4 March 2013

**Modification to Site 4B Commercial Development (MP06\_0273 MOD 4)**

**Andrew Brown**

**Executive Manager, Urban Planning and Design**

SITE 4B
SYDNEY OLYMPIC PARK
GROUND FLOOR PLAN

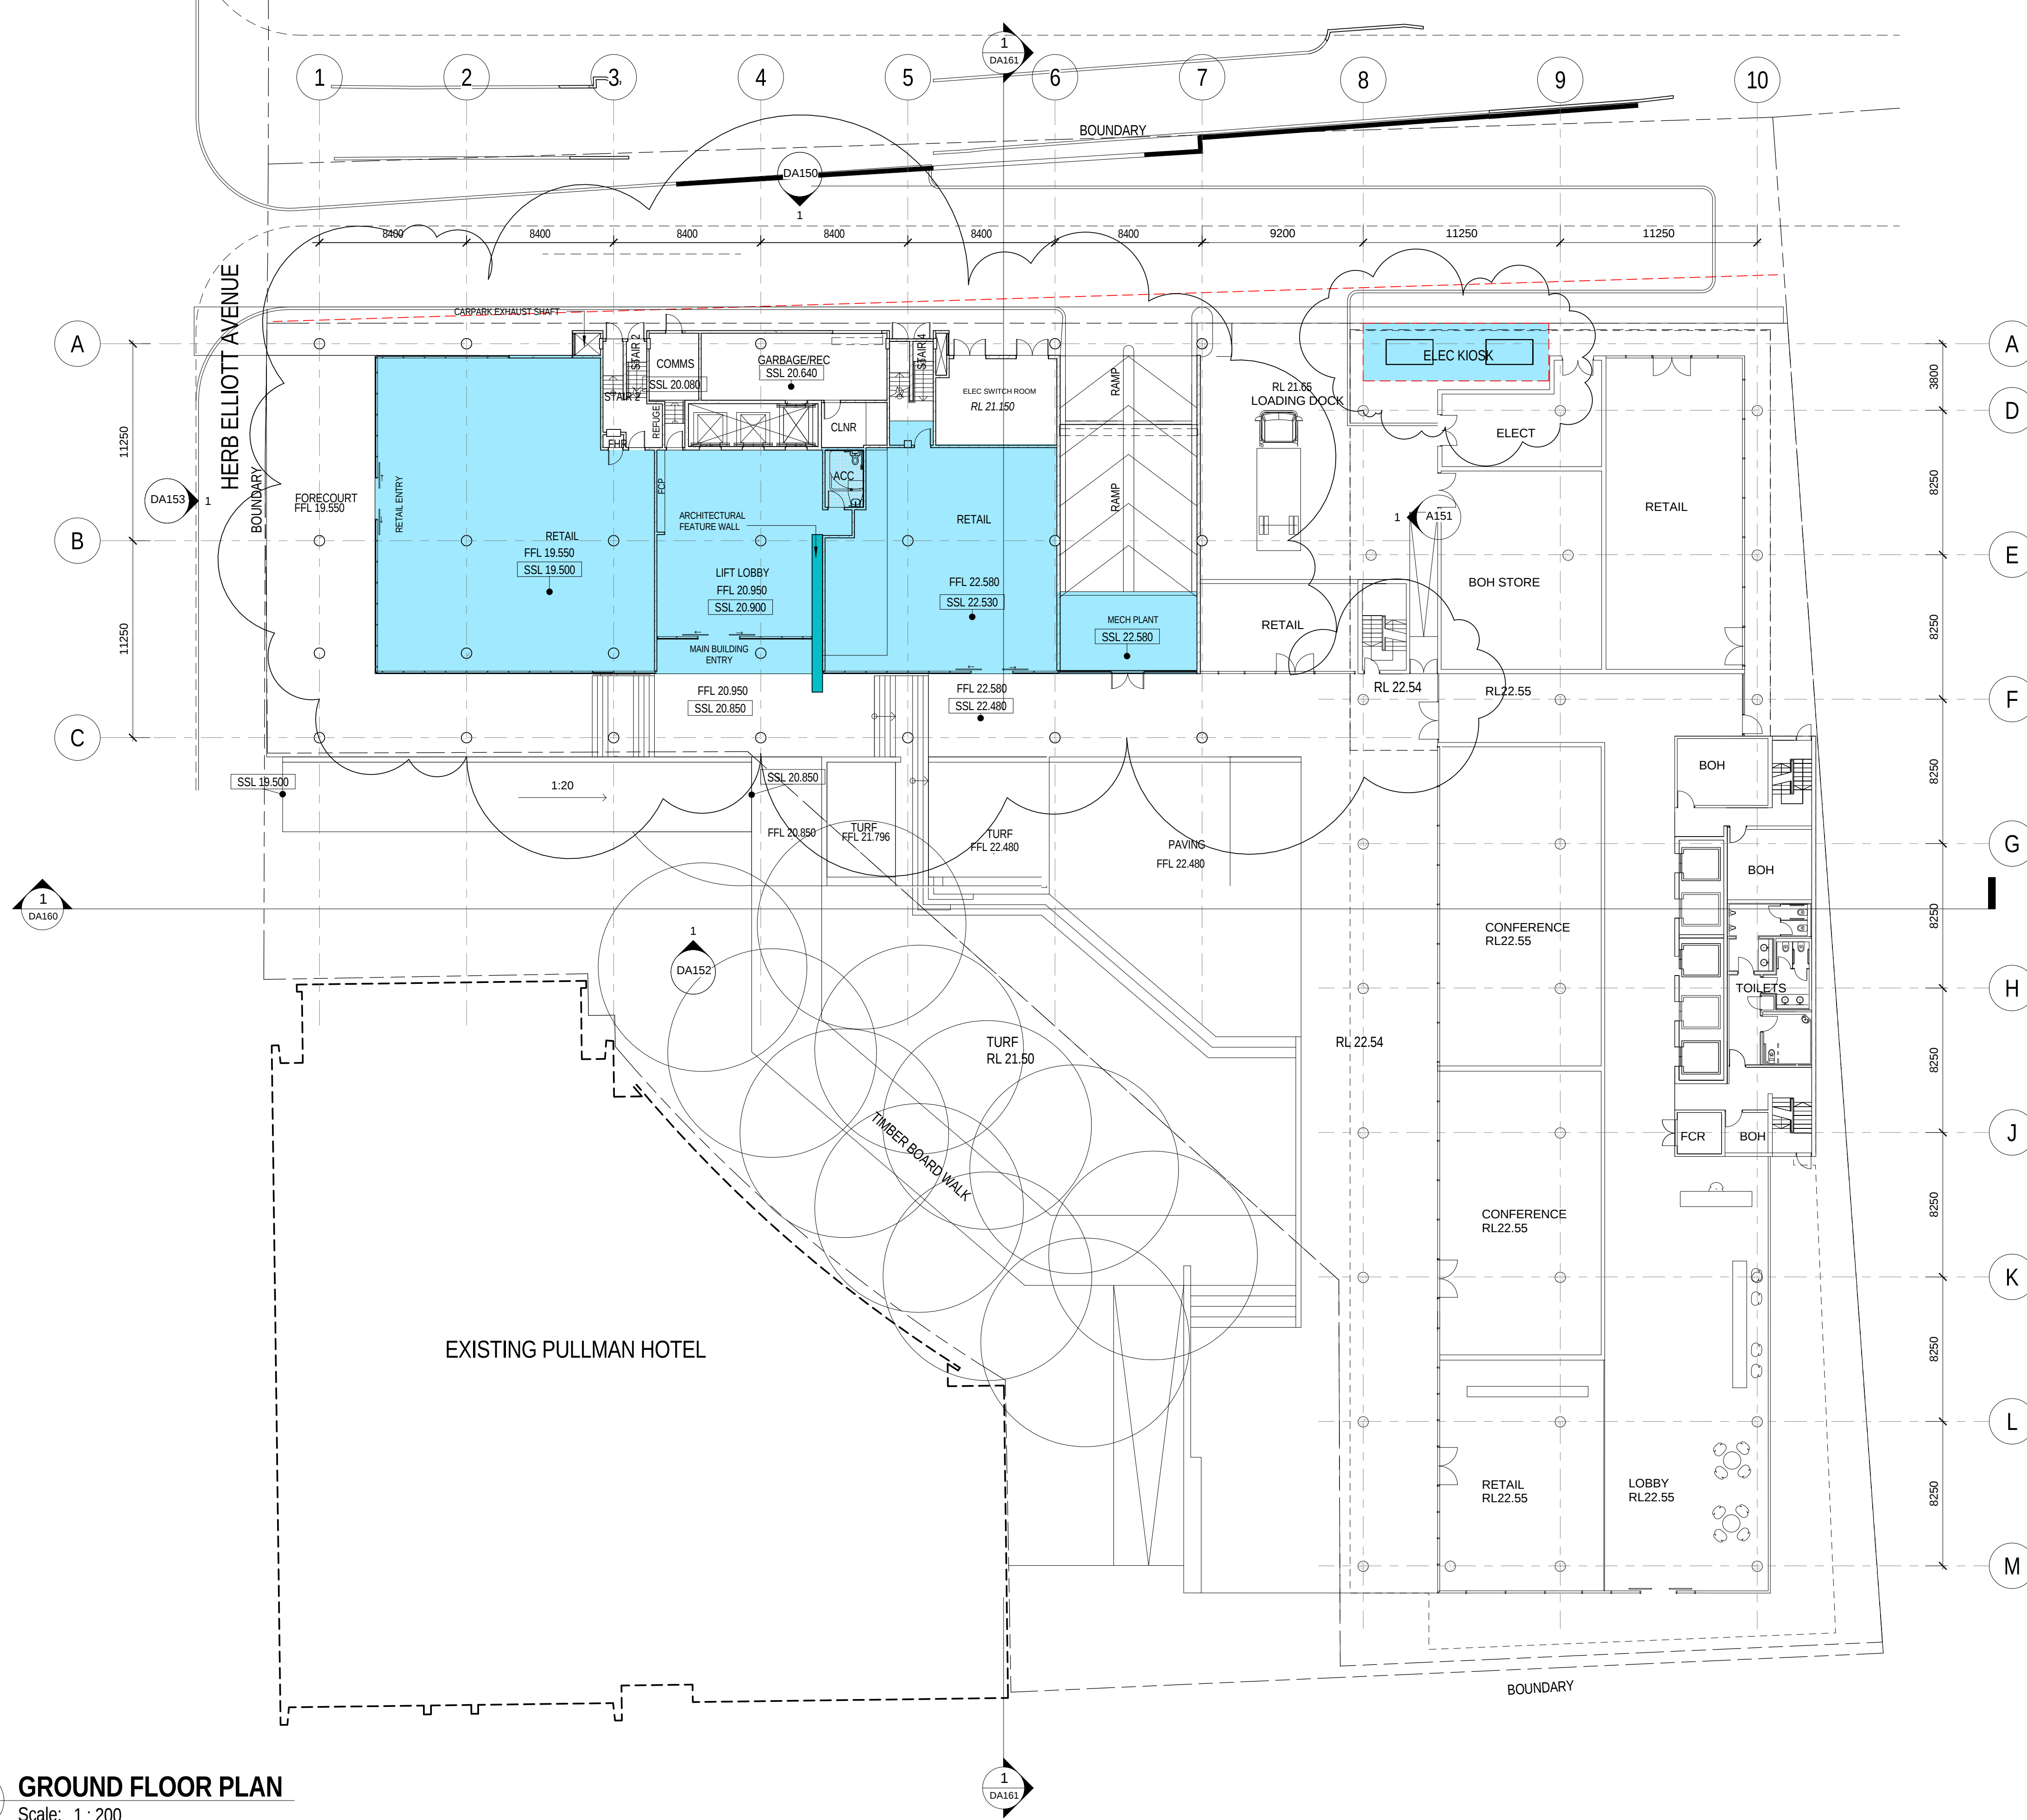
The relocation of the Foyer and reconfiguration of Retail Space has resulted in the smaller of the two Retail Spaces (FFL 22.580) to be non-compliant with the DDA. Accordingly, the Public Domain Plan should be revised to ensure compliance with the DDA and SOPA's Accessibility Guidelines.
